City of Portland, Maine - Building or Use Permit Application
 389 Congress Street, 04101 Tel: (207) 874-8703, Fax: (207) 874-8716

Permit No: 05-1732	Issue Date:	CBL: 431 E017001
------------------------------	--------------------	----------------------------

Past Use: Single Family	Proposed Use: Single Family add 6' in hieght to existing story to create 3rd floor before putting on the roof.	Permit Fee: \$75.00	Cost of Work: \$6,000.00	CEO District: 4
Proposed Project Description: Add 6' in hieght to existing story to create 3rd floor before putting on roof.		FIRE DEPT: <input type="checkbox"/> Approved <input type="checkbox"/> Denied	INSPECTION: Use Group: Type	
		Signature:	Signature:	
PEDESTRIAN ACTIVITIES DISTRICT (P.A.D.)				
Action: <input type="checkbox"/> Approved <input type="checkbox"/> Approved w/Condition <input type="checkbox"/> Denied				
		Signature:	Date:

REVISION TO CAIRNES ADDENDUM

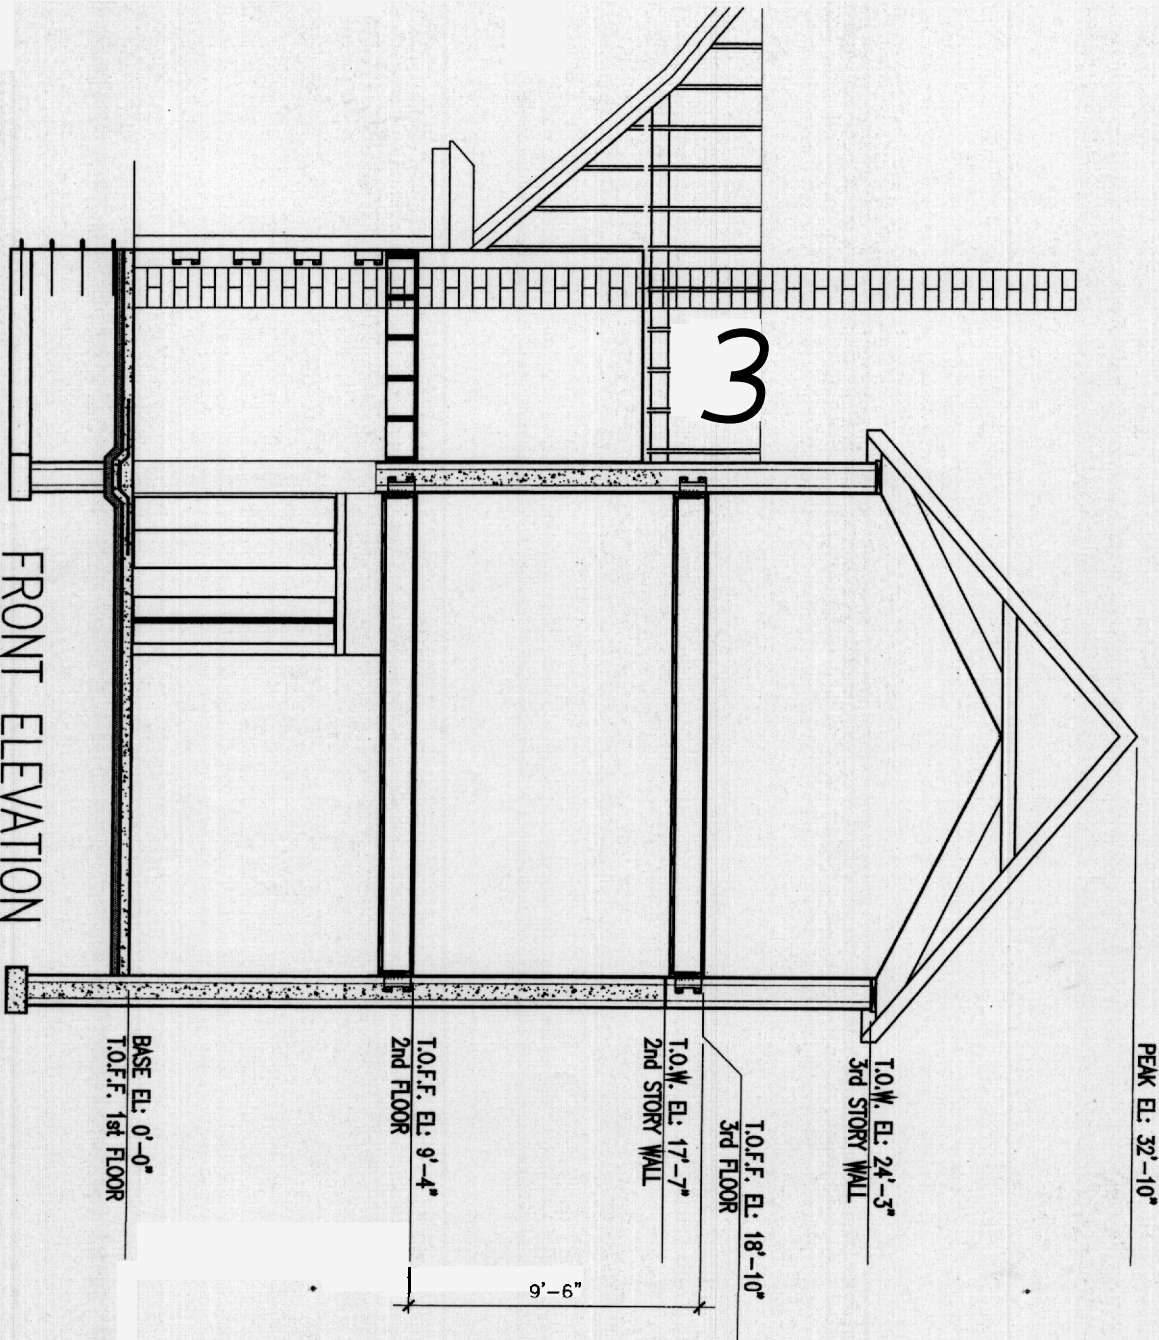
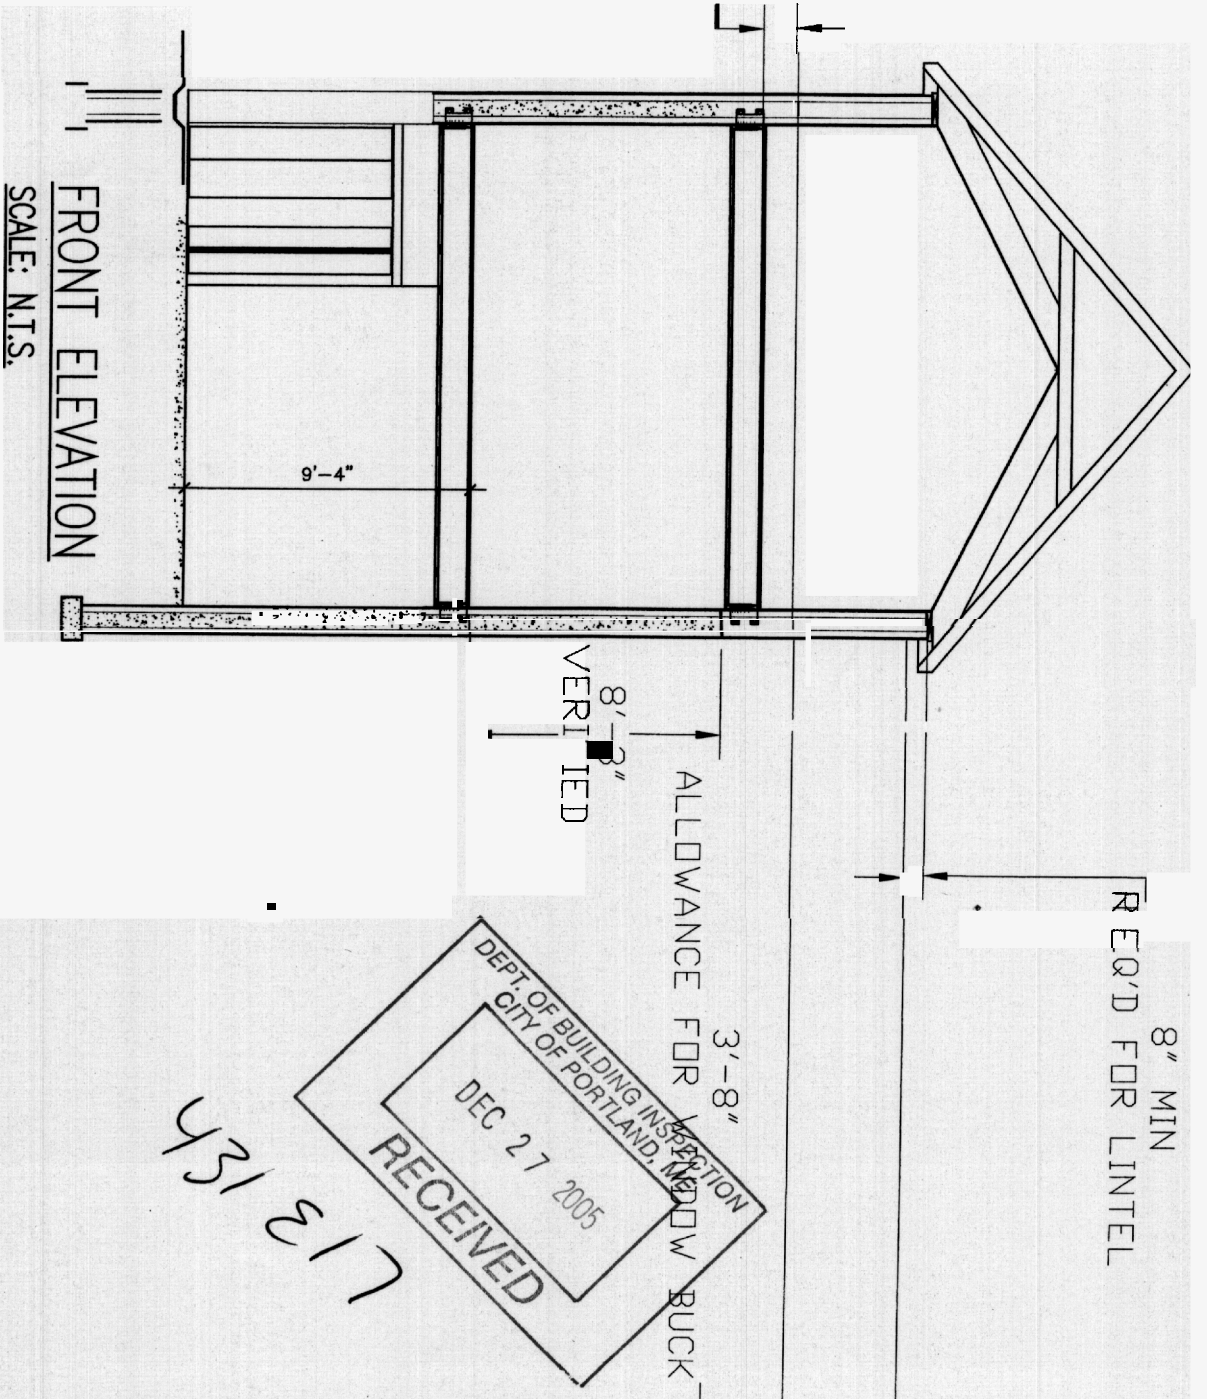
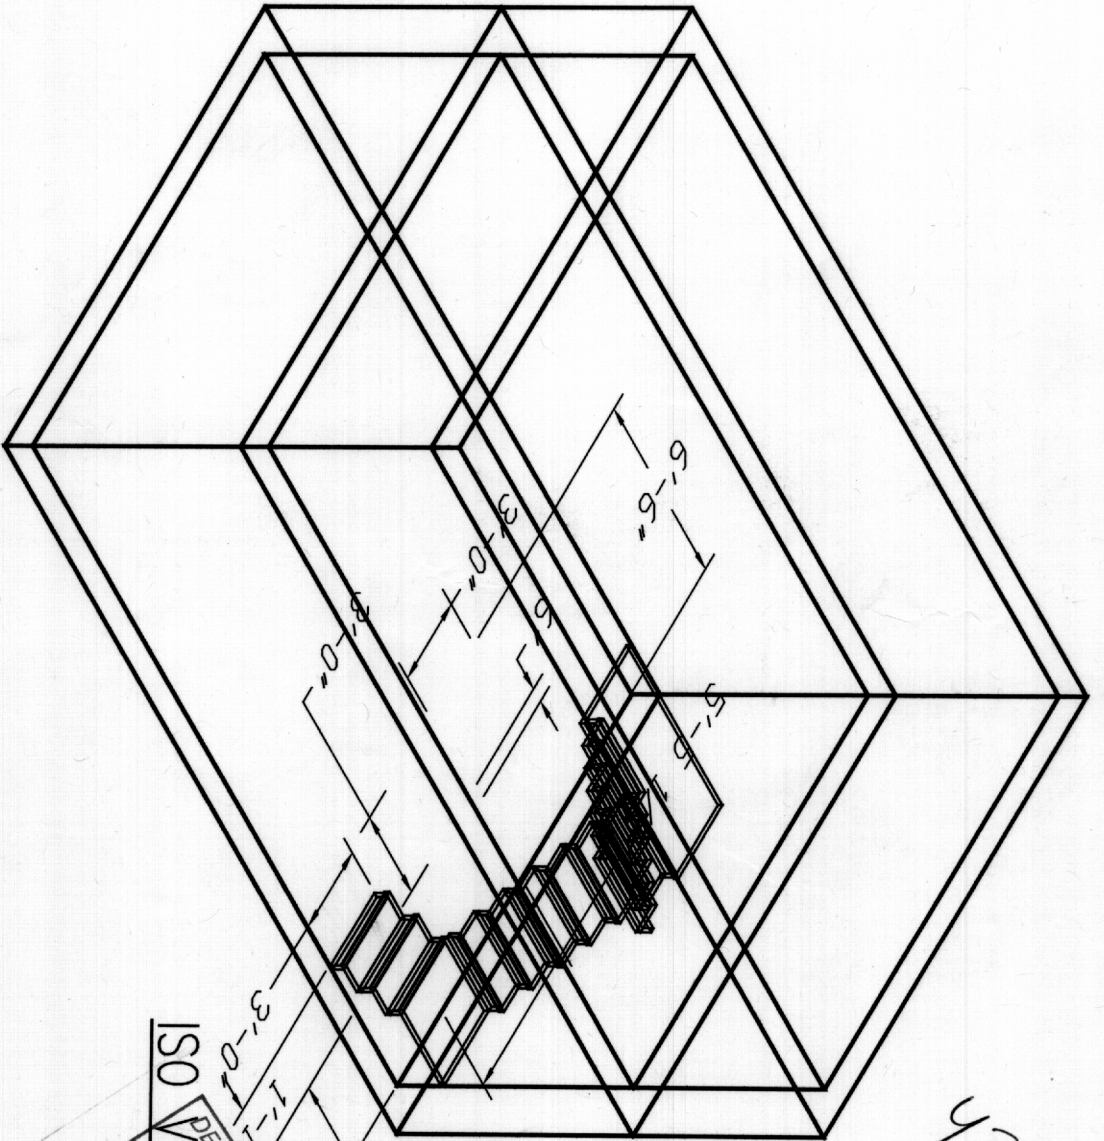
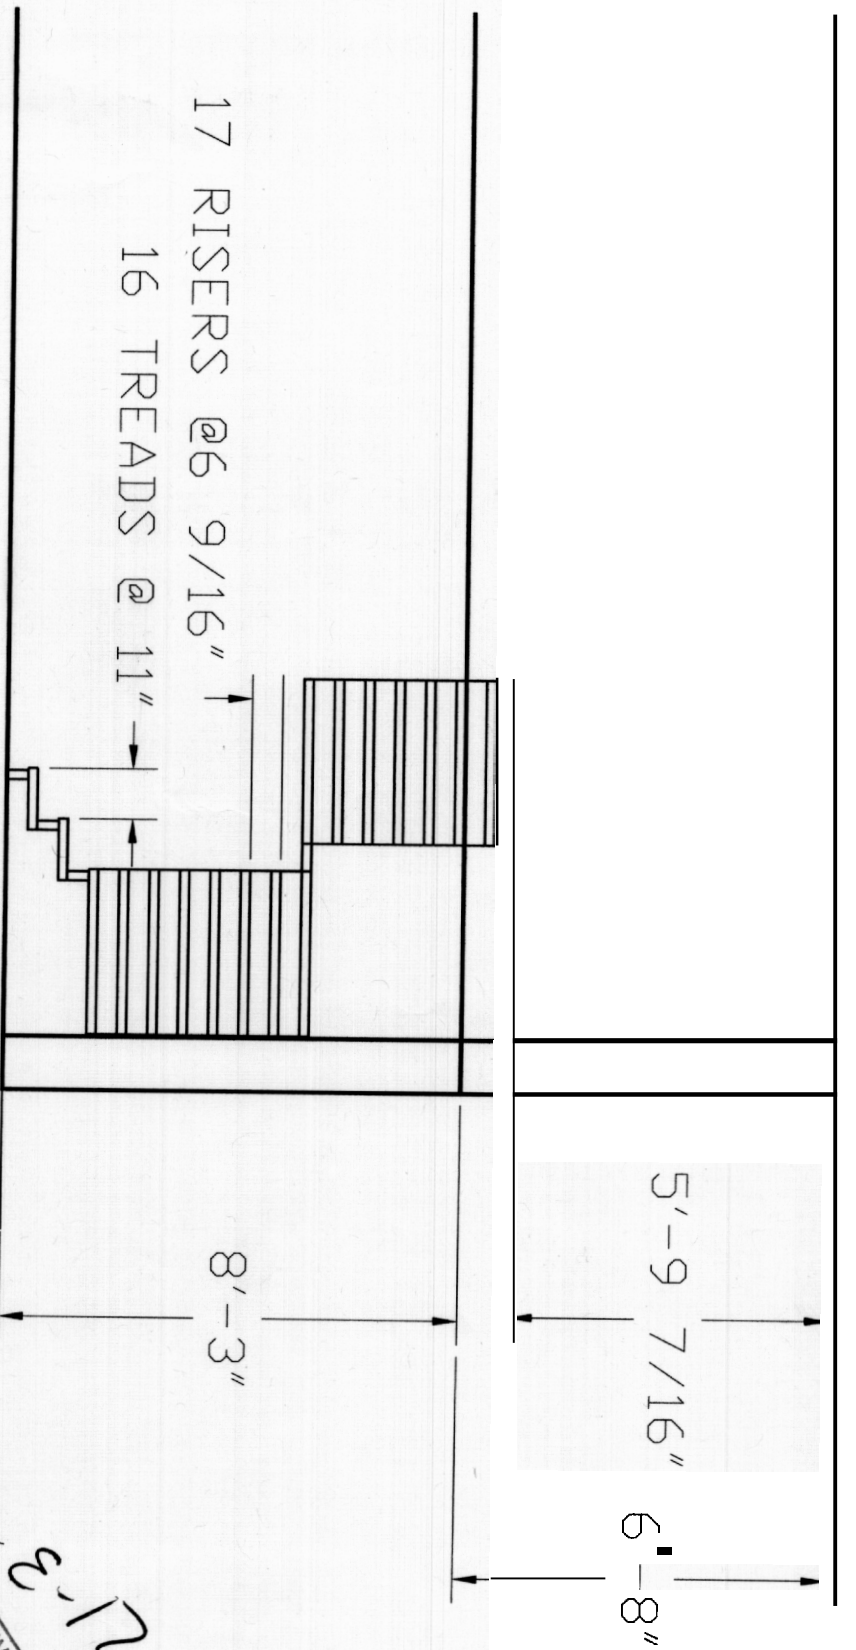
12/6/05-tmm: spoke w/Joel York - need to show design to structure can carry another story and need floor hanger detail.

12/22/05-tmm: rec'd additional engineering -ok to issue
